KITTITAS COUNTY
ROAD VARIANCE COMMITTEE

RV-19-00003
Mitch Williams

**FINDINGS OF FACTS,
CONCLUSIONS AT LAW, AND
DECISION**

DRIVEWAY AND BRIDGE SITE PLAN  
DRAWING 10

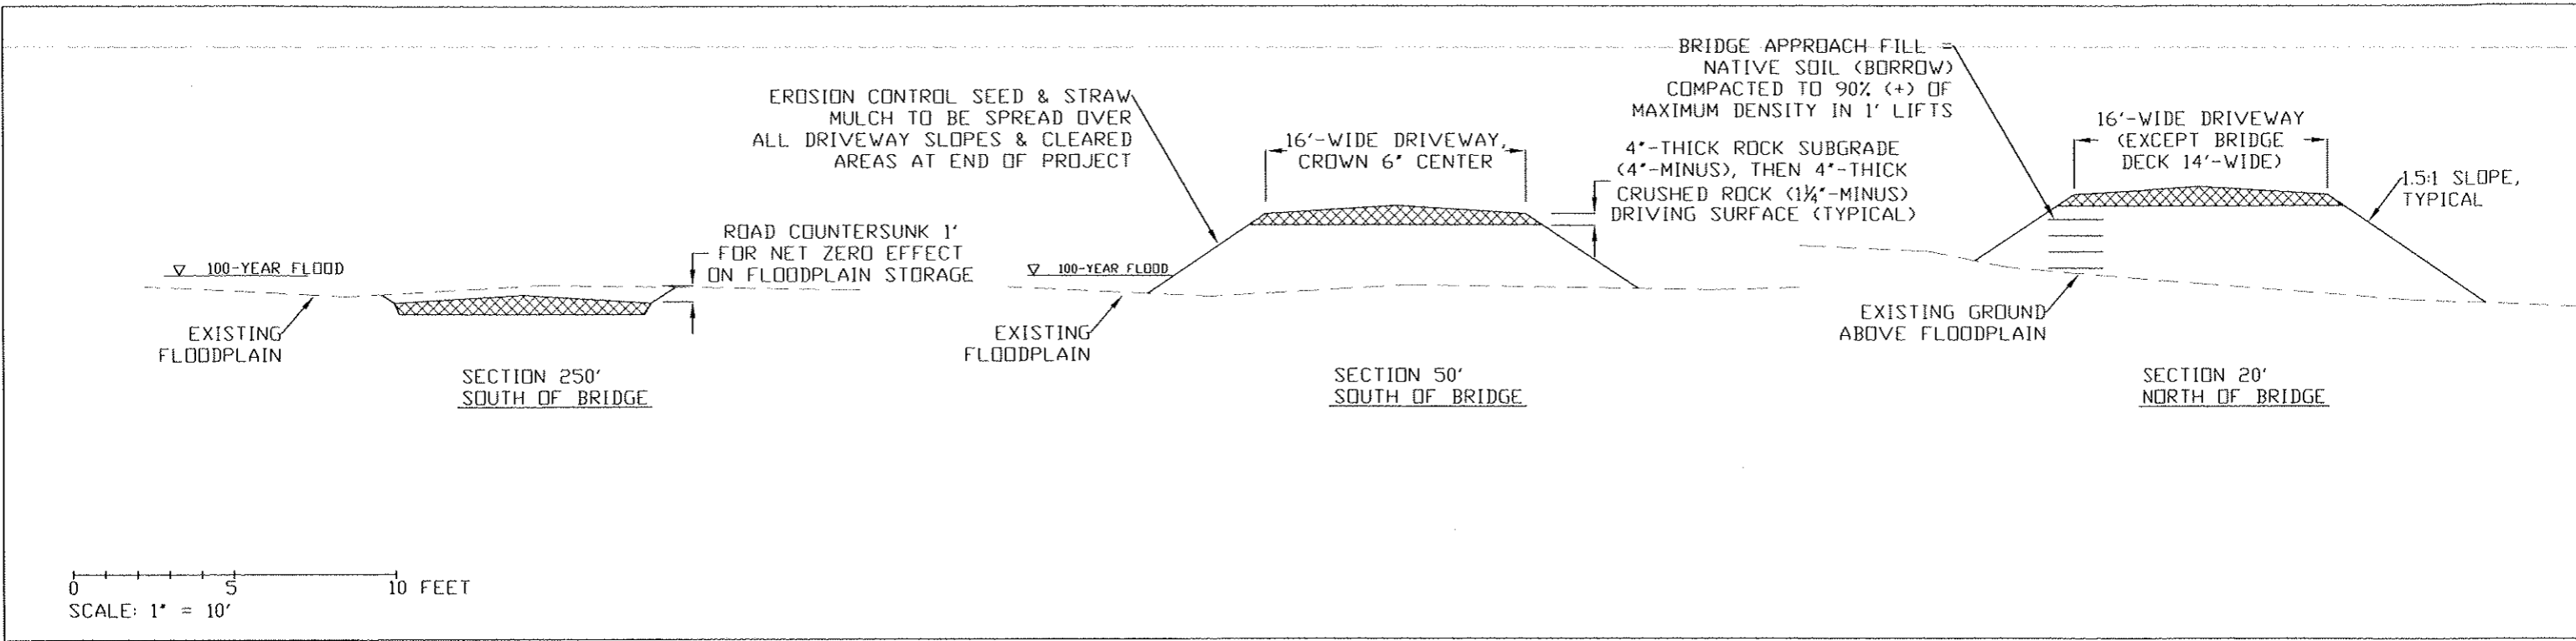
4. The Committee Finds that Chapter 12.04.080 Table 4-4 requires that driveways over 150' in length be a minimum of 16' wide driving surface.
5. The Committee finds that the applicant is seeking a variance, allowing a 14' wide bridge.

7. The Committee finds that the proposal is not in the public interest and that requirements for safety function, fire protection, appearance and maintainability based upon sound engineering judgment are not fully met, as required by KCC 12.01.130.
8. The Committee finds that additional conditions are necessary to protect the public's interest, specifically that the bridge be 16 feet wide.

Mark Cook called the meeting to order at 2:02 pm. Kelly Bacon presented the road variance. The applicant is asking for a variance to the width requirement for a bridge from 16' wide to 14' wide. Patrick Nicholson stated he has concerns in regards to fire apparatus access road width supporting vehicles crossing the proposed bridge. He stated that a narrow bridge would become a choke point during emergencies. Mark Cook stated that Public Works is currently in the process of replacing a primitive road bridge on Fish Lake Road, which is going to be 16' wide in keeping with commitment to fire life and safety. Public Works supports a 16' wide structure. Dan Carlson stated there are no planning and zoning issues. Dan asked if the applicant provided pullouts on either side of the bridge, if that would address the issues. Patrick Nicholson was interested in hearing Chief Rich Elliott's opinion on the pullouts option, but would be willing to consider. Rich Elliott went over the email he sent on March 7, 2019 regarding to the concerns the Fire Districts have with a non-compliant bridge. He stated that during an emergency there would most likely be hose laid across the bridge. Ice or smoke causes narrower crossings, and adding that to an already narrow bridge would complicate response and evacuation. If the compliant bridge at 16' wide did not fit in the location, consideration of a narrower bridge would make more sense. In this

instance that is not the case and it is simply for cost. If approved, the committee would be setting precedence. Dan Carlson stated that the code for road variance can consider hardships, but not cost. Patrick Nicholson stated that turnouts would address one concern but not all concerns. If there are no other reasons other than cost, he would be inclined to stay with the 16' requirement.
